Reference No: 2021/62/90944/E

Site Address: 78, Hopton Lane, Mirfield, WF14 8JS

Description: Erection of single storey extension to rear with raised patio and balustrade, demolition of existing conservatory

DECISION – CONDITIONAL FULL PERMISSION

| 2021/ 282/ 03 |    |                                          |          |

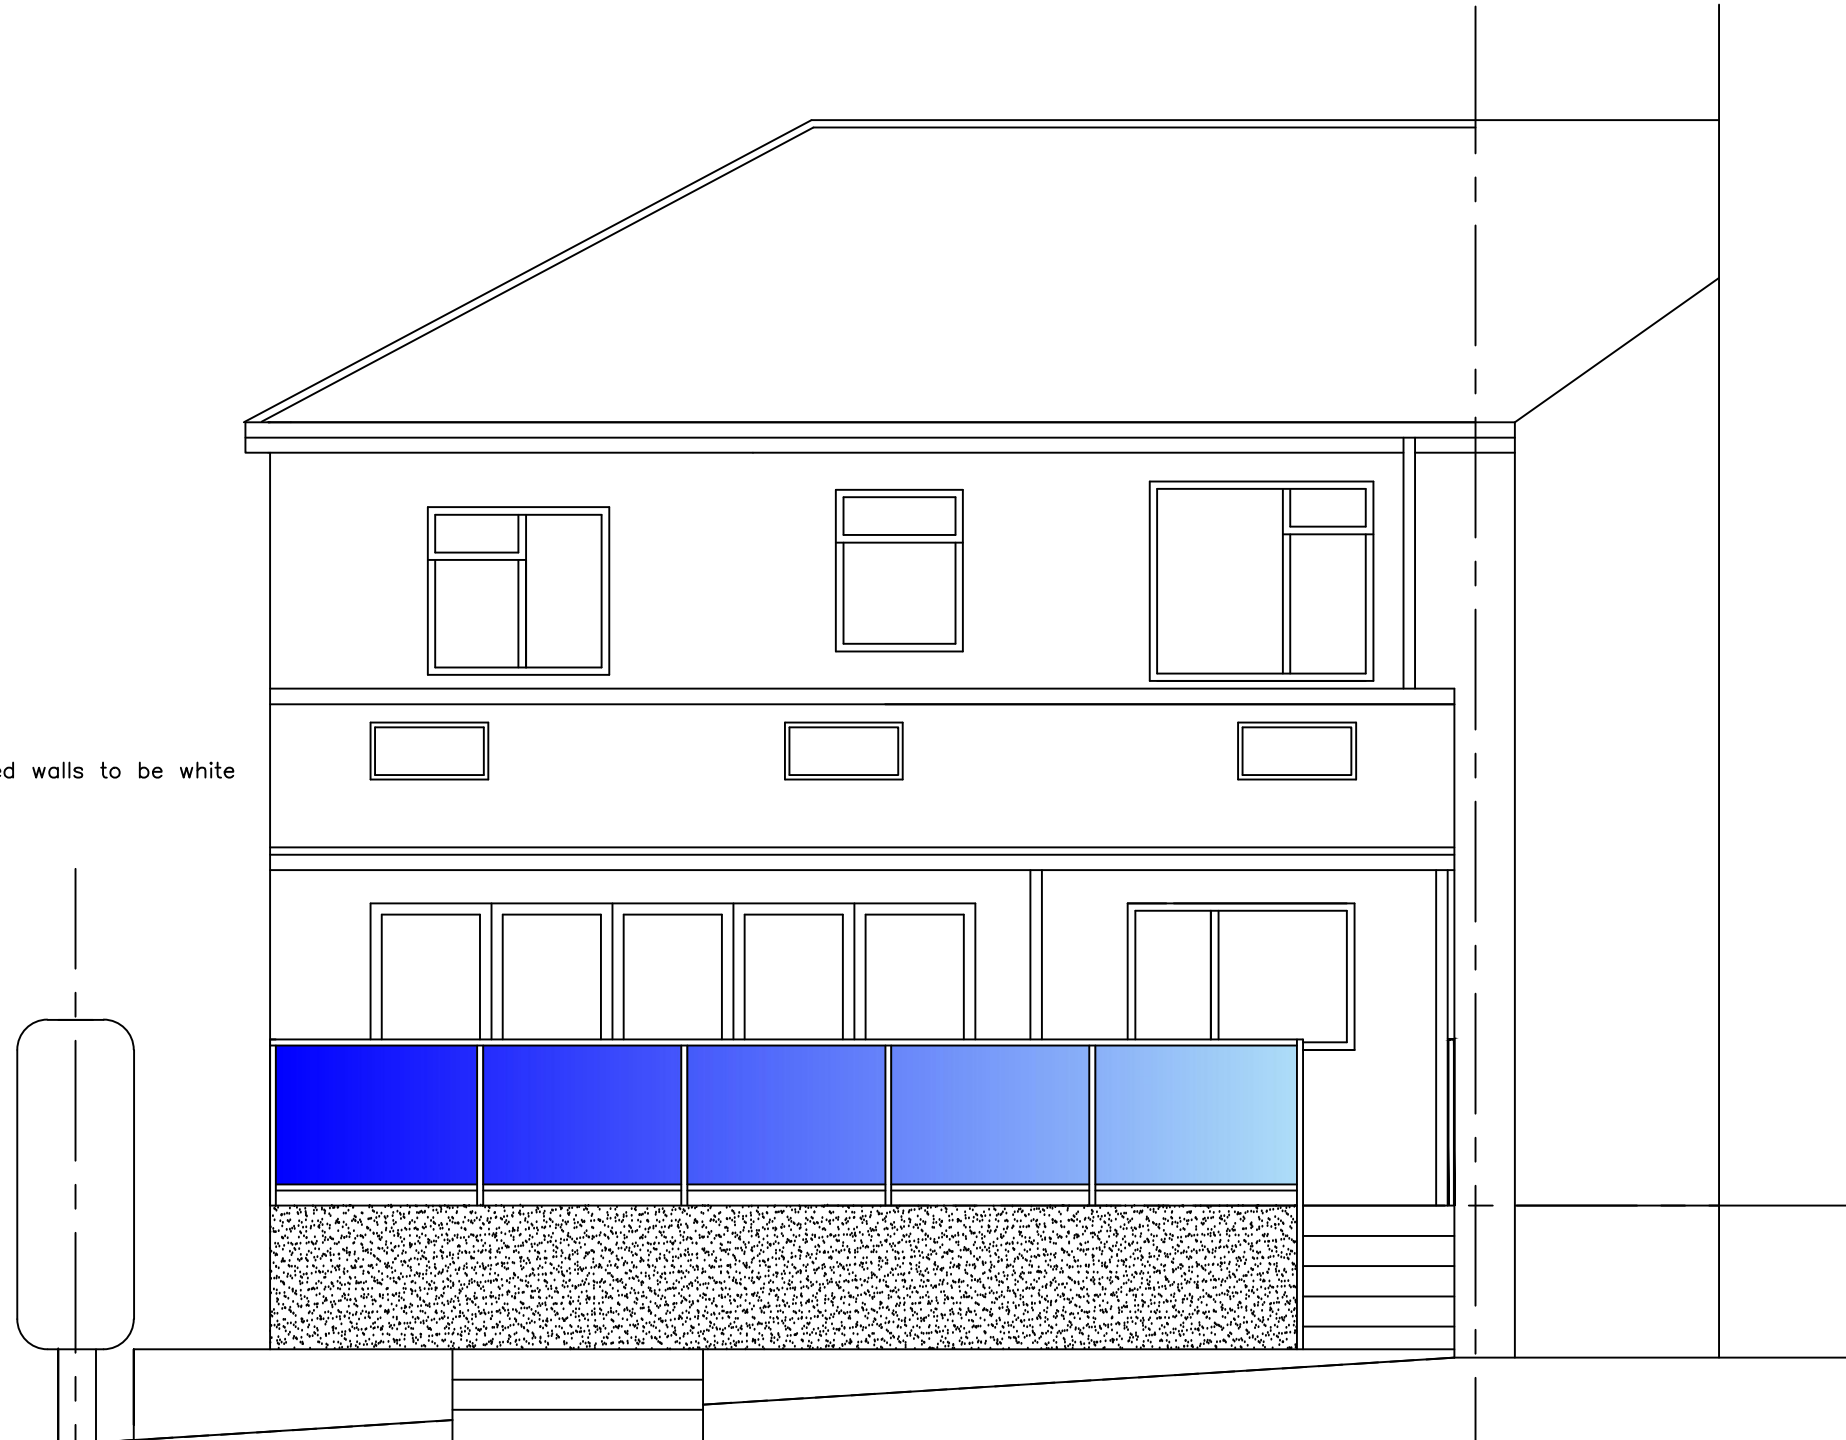
Initially, the proposal saw a 3m raised patio proposed, which ran the full width of the dwellinghouse. Officers considered that this would detriment the residential amenity of the attached neighbour given it provides the ability to look back into the neighbouring dwelling. Furthermore, this size of raised patio could facilitate intense usage which would, again, impact on the amenity of the neighbour dwellings through loss of privacy and noise. After discussions with the agent, Officers requested the agent reduced the size of the deck to 2m and set it in off the side closest to the attached neighbour. The agent made these amendments, as shown on the plans received on 23/03/2021.

It is considered that there would be some impact on the amenity of these neighbours, given the fact that the proposal would intensify development to the rear of the application site. However, amendments were sought to inset the patio in from the shared boundary by 0.7m and reduce the projection of the patio. The lean-to roof form and modest projection of the extension also mitigates any harm. The proposal is, therefore, considered acceptable and no harm to residential amenity, on overbearing or overshadowing grounds, would be caused to no 80. The existing boundary treatment will also mitigate any harm.

There would also be no undue harm on overlooking as the plans show there to be no additional windows inserted into the western-facing element of the extension. The inseting and reduction in size of the patio also restricts the ability to look back into the windows on no.80.

Initially, the proposal saw a 3m raised patio proposed, which would have run the full width of the dwellinghouse. Officers considered that this would be detrimental to the residential amenity of the attached neighbour, given it would provide the ability to look back into the neighbouring dwelling. Furthermore, this size of raised patio could facilitate intense usage, which would also impact on the amenity of the neighbouring dwellings, through loss of privacy and noise. After discussions with the agent, Officers requested the agent reduce the size of the deck to 2m and set it in off the side closest to the attached neighbour. The agent made these amendments as shown on the plans received on 23/03/2021.
